Please upload onto Ocella the email trail below and the attached **Supporting Statement** for application **LU/141/21/PL**.

Please **amend the application** from a full application to a **reserved matters application** on Ocella and re-number the application to **LU/141/21/RES**.

- Application **LU/141/21/PL** is a reserved matters application and not a full planning application.
- What is the site area (in hectares) of the minor amendments to Plots 123-126 and the revision to the parking space at Plot 38?

Drawing Title: **Single Garage  
Proposed Plans and Elevations**

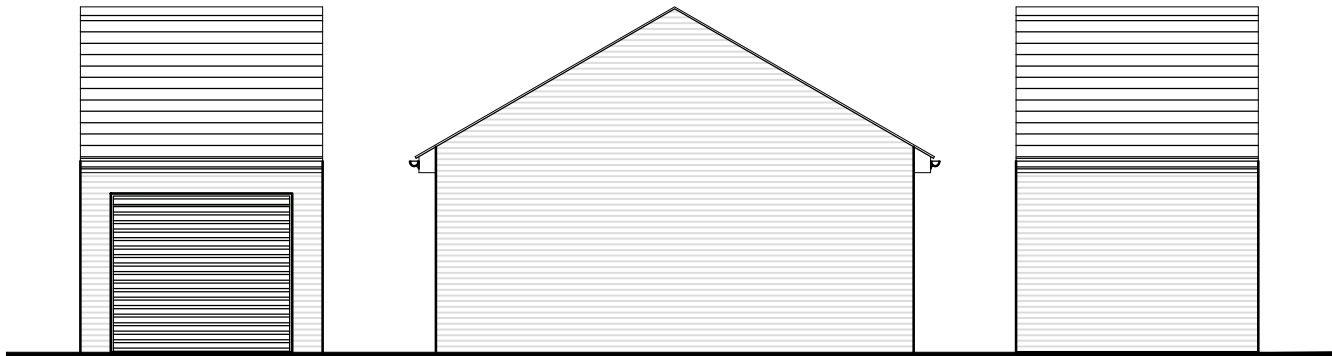
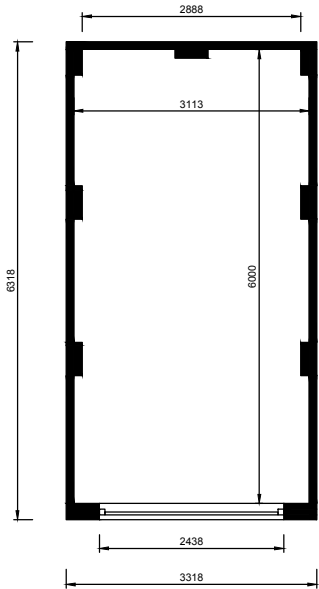
- Why have you submitted Drawing No. 543_PL_APP3_GAR_100 - Single Garage: Proposed Plans and Elevations when the garage serving plot 38 is being replaced by a car parking space?

Please disregard Drawing No. 543_PL_APP3_GAR_100 - Single Garage: Proposed Plans and Elevations.
